From: Mark Warwick
Sent: 14 February 2019 17:01
To: Simon Davis
Cc: Planning.Responses
Subject: AW/279/18/RES

Planning Application Ref: **AW/279/18/RES**

Location: **261 Aldwick Road, Aldwick, PO21 3QU**

Description of works: **Application for approval of reserved matters following outline approval AW/43/18/OUT for the demolition of existing dwelling & erection of two pairs of semi-detached houses & associated works**

LLD-ARB-DWG-002

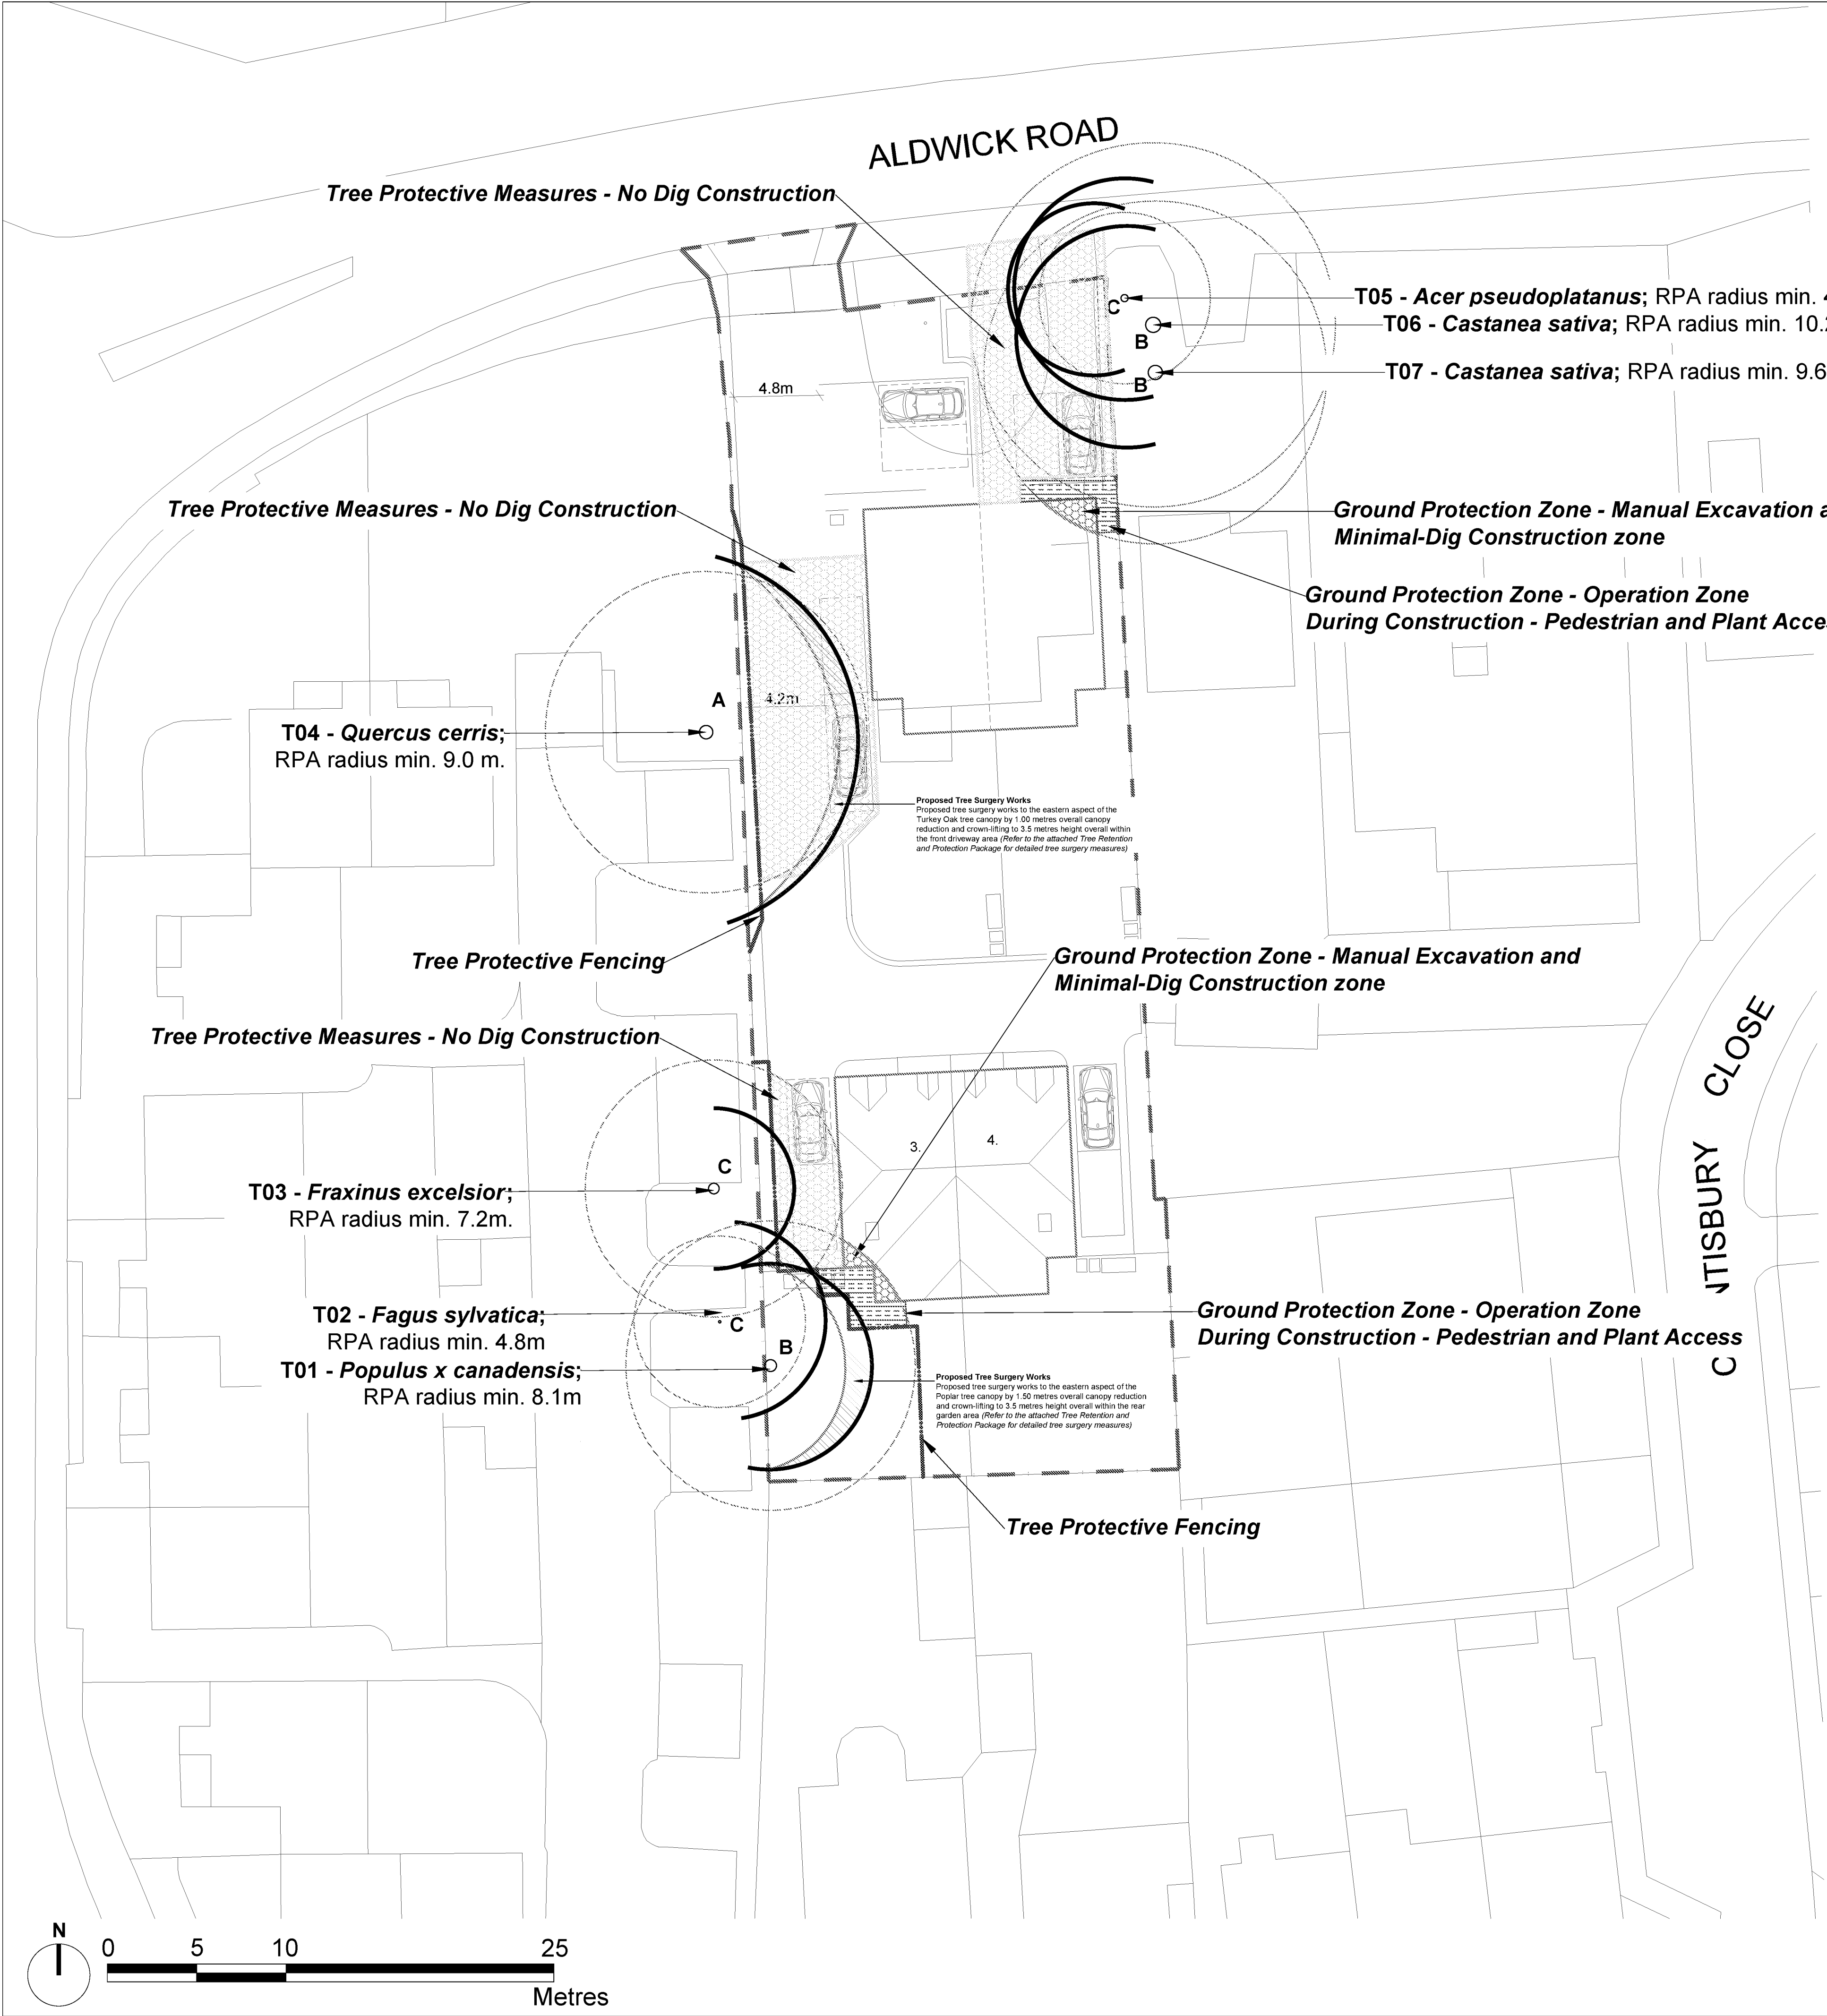
- I remain concerned with the 'Minimal-dig' Construction methodology as described in the AIA/AMS, 21/June/18, Rev 01 (p13, para. 4.29) which states that existing soft ground layers within Root Protection Areas are to be removed so as to provide the necessary construction depth and to meet with existing hard surface levels. This is not a 'No-dig' Construction, which is the only methodology I could support alongside these valuable trees.

The extent and depth of proposed ground level alteration has not been provided in detail or shown on any cross-section drawing, so we cannot be sure these trees will not suffer significant damage. Is it not possible to 'build up' soil levels slightly to achieve an acceptable platform, that better respects the trees?

If they can resolve the above concern to my satisfaction, by way of demonstrating how a true 'No-dig' Construction can be achieved across the site at those three areas identified on their Tree Retention and Protection Plan, dwg.no.LLD-ARB-DWG-002, Rev00, 21.06.18 and clearly write this into their AIA/AMS and to correspond with the TPP; then I would be able to remove my objection and recommend approval subject to the following conditions being applied:
